Lang Walker AO Medical Research Building – Macarthur (SSD-17491477)
Request for additional information

I refer to the assessment for the Lang Walker AO Medical Research Building – Macarthur (SSD-17491477). The Department requires additional information regarding the proposal to enable progressing of the assessment of the application.

Figure 25 – Flood Impact Assessment Map (1% AEP Flood event)

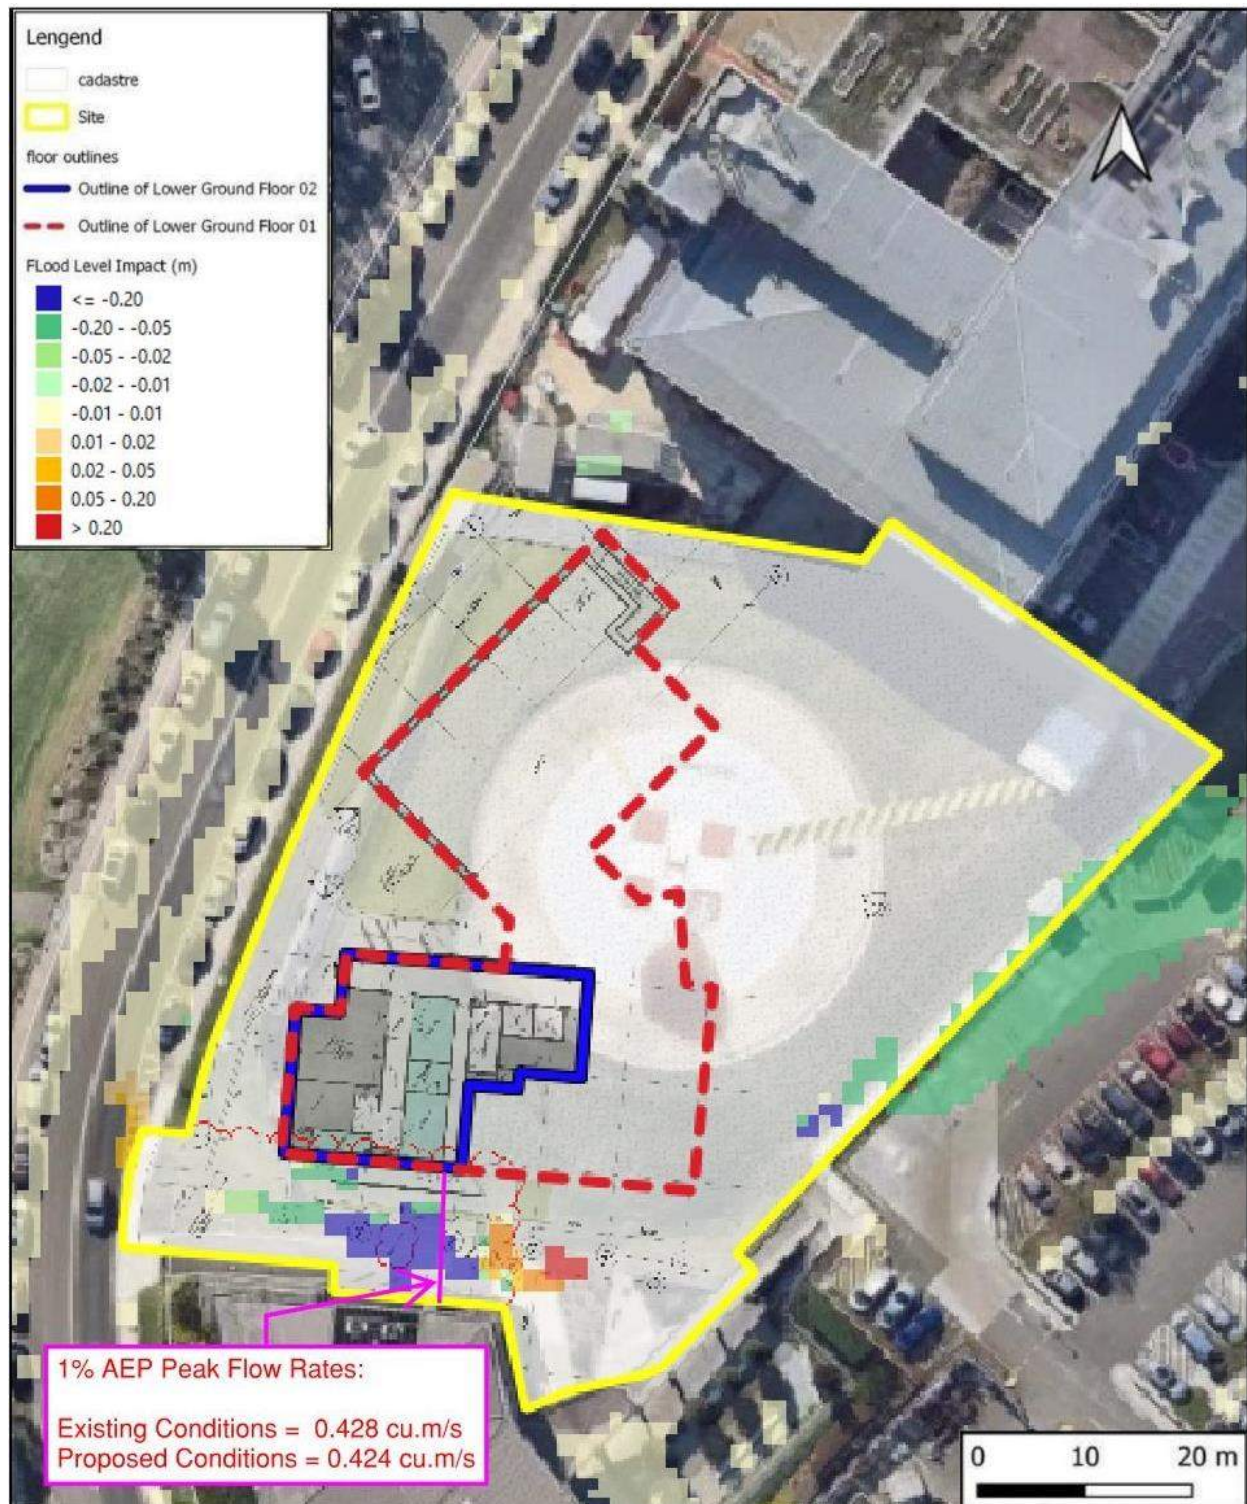
- Figure 25 of the revised Flood Assessment Report (25 March 2022) should be amended to demonstrate a band of -10mm to +10mm level difference, as noted in the report.
